**Application: SSI 7485**

I write regarding the proposed modification to M4-M5 Link, Mod 2 The Crescent overpass and changes to pedestrian infrastructure in North Annandale, Rozelle and Rozelle Bay Foreshore area.

Figure 4-2 Pedestrian and cyclist bridge infrastructure options

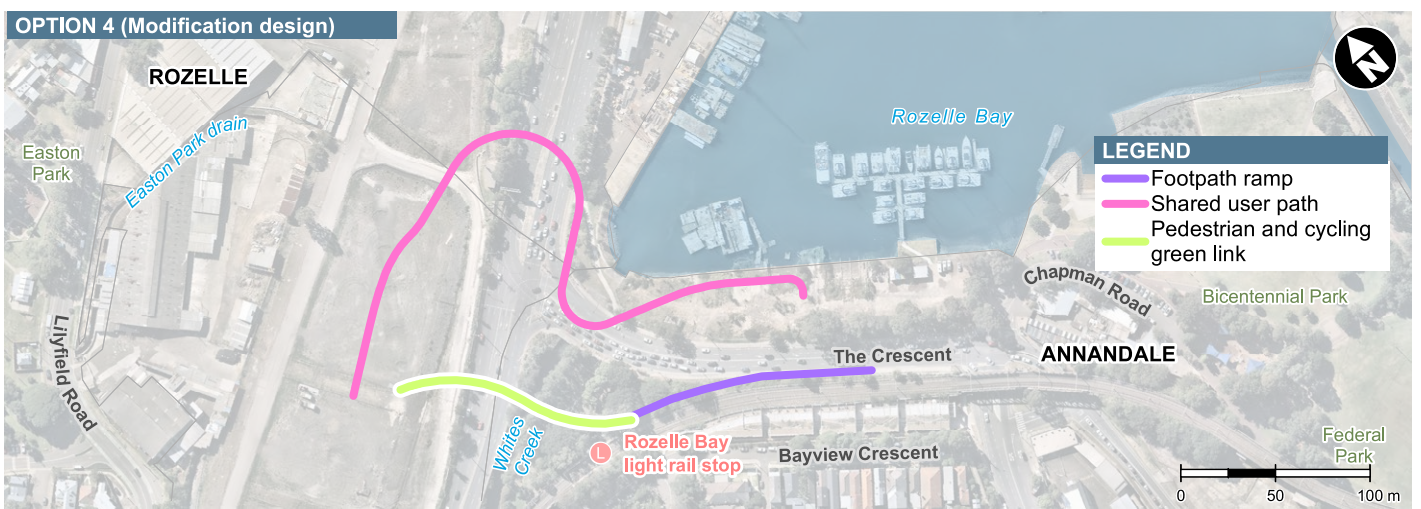
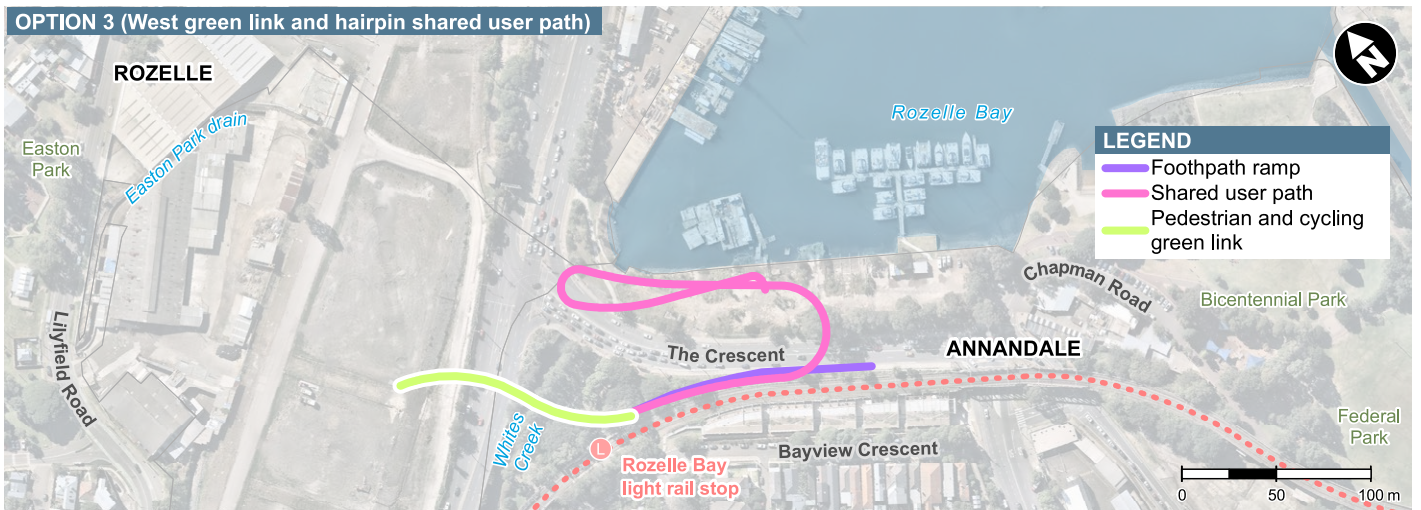
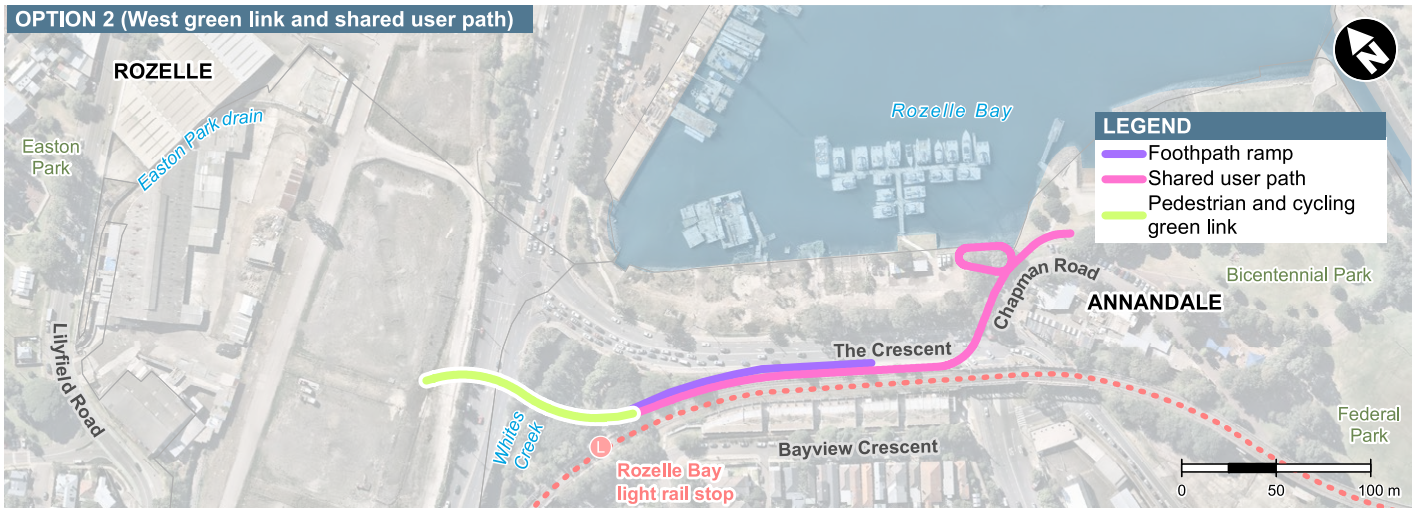
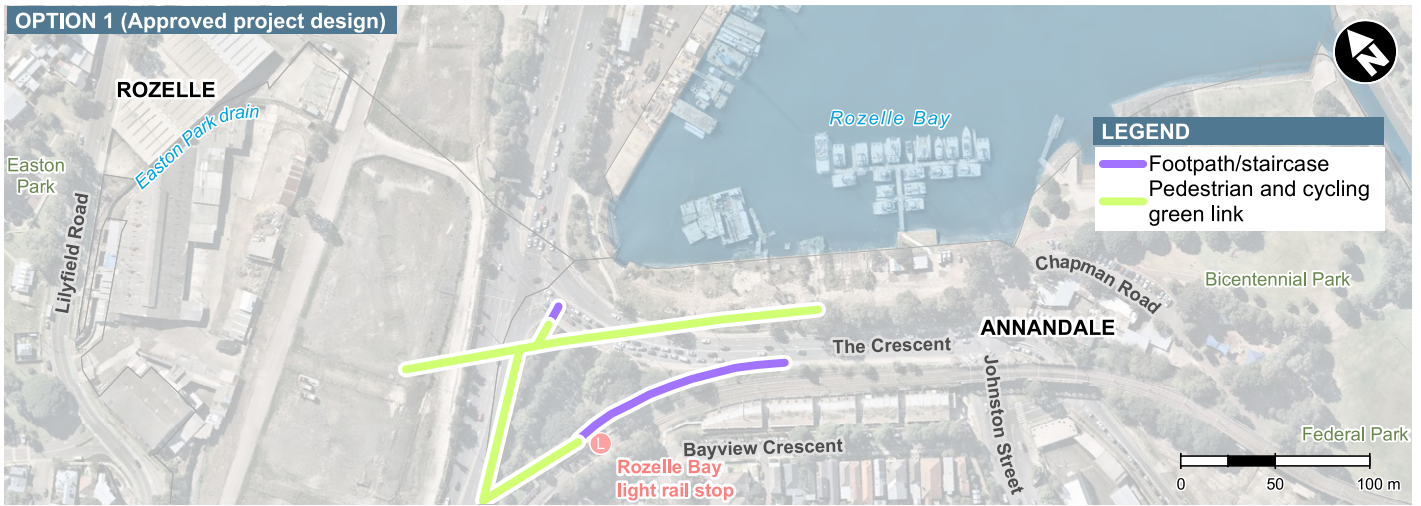
I request RMS work with the community to explore alternate design options to the proposed new car overpass design and the changed pedestrian and cyclist links. I am seeking the reinstatement of the safe, direct access from the approved EIS GreenLink to create a continuous green open space connection from the Rozelle Rail yards and Annandale to the foreshore. The GreenLink was more than just a walk way - it put people central to the design, maximising safety, and providing much needed accessible open space for the community now and into the future Bays Precinct design.

- The significantly reduced safety and increased risk for pedestrians and cyclists with removed access over The Crescent to Bicentennial Park and the increased traffic along Johnson Street.
- Being required to cross five sets of pedestrian lights at The Crescent as my option to reach the foreshore from Annandale or from Rozelle Bay light rail stop.
- Removal of direct active links to the foreshore, cutting the community off from the area and the proposed revitalisation of the entire Bays Precinct, including linking the Light Rail and Bus stops to a Ferry wharf and Metro station.
- Urban and landscape design that is being built before a finalised Masterplan for the area.
- Traffic changes that limit movements around the suburb and create further congestion in the local streets of Annandale, Forest Lodge, Glebe, Lilyfield and Rozelle with no planning to deal with these.

Figure 4-4 Elevation: Indicative view of The Crescent overpass

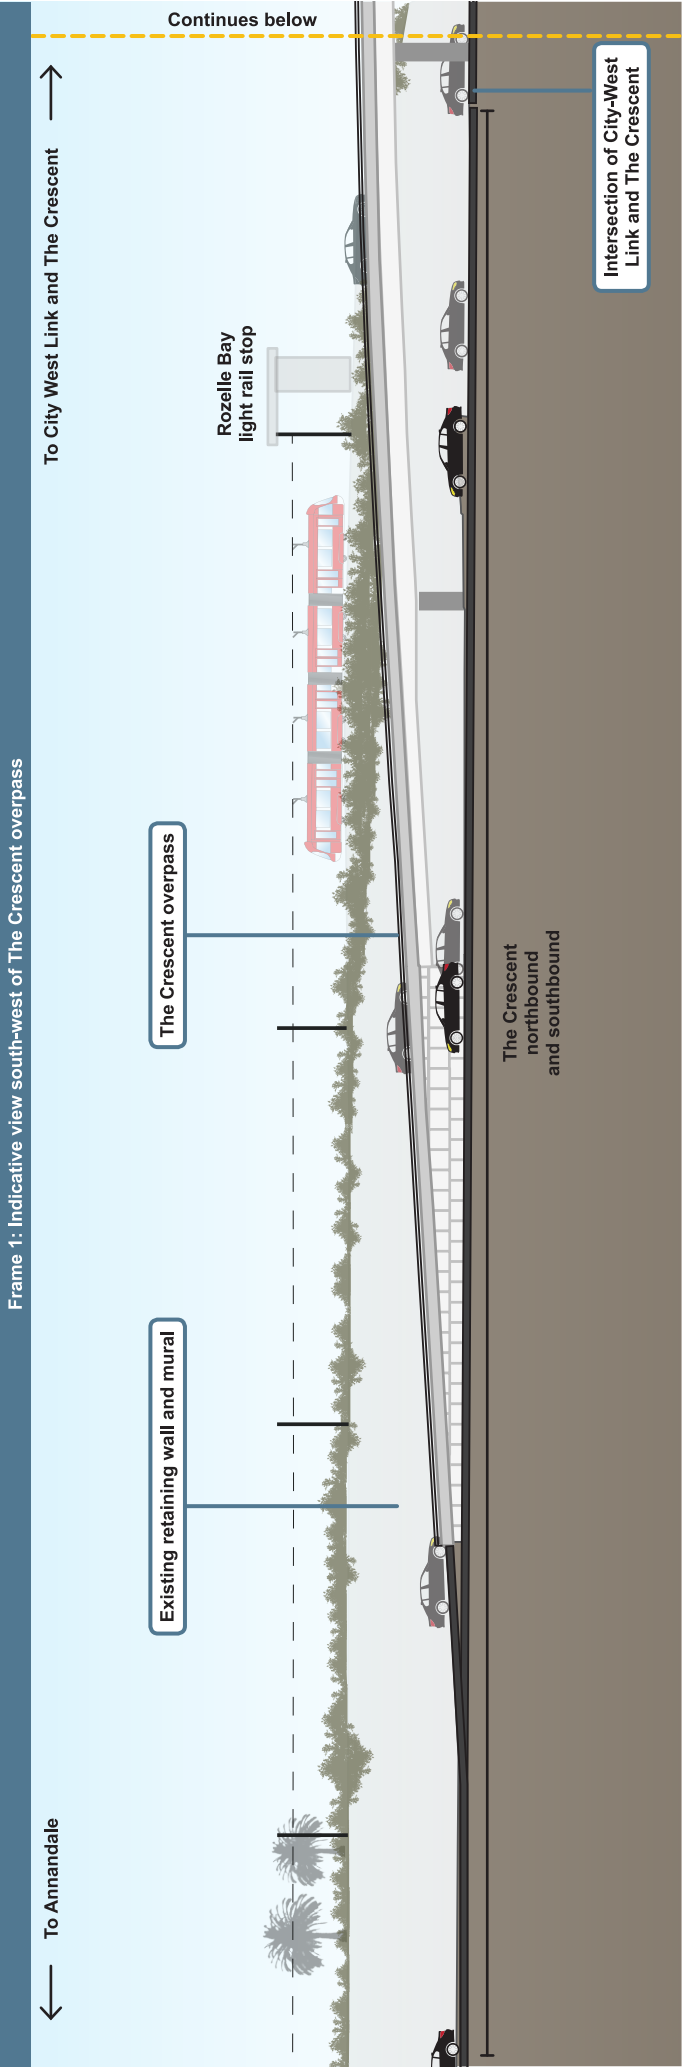
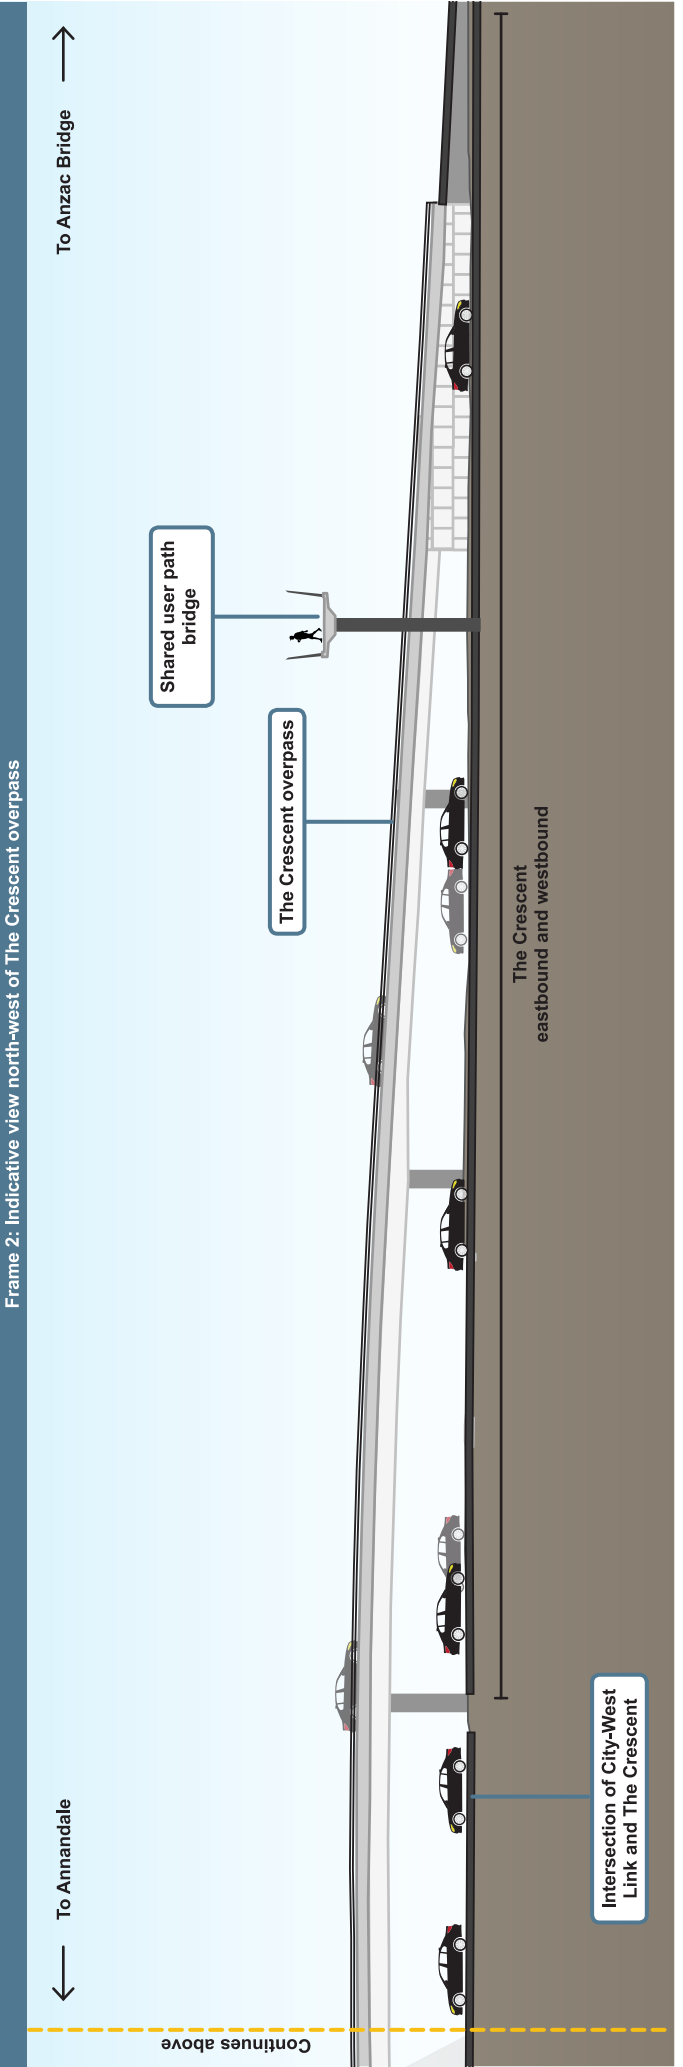
THE PROPOSED VEHICULAR OVERPASS IS  
NOT APPROPRIATE IN SUCH A CONSTRAINED  
SITE - BETWEEN THE LIGHT RAIL AND  
ROZELLE BAY. PLEASE CONSIDER RETAINING  
AN ON GRADE INTERSECTION OR VEHICULAR  
UNDERPASS INSTEAD.
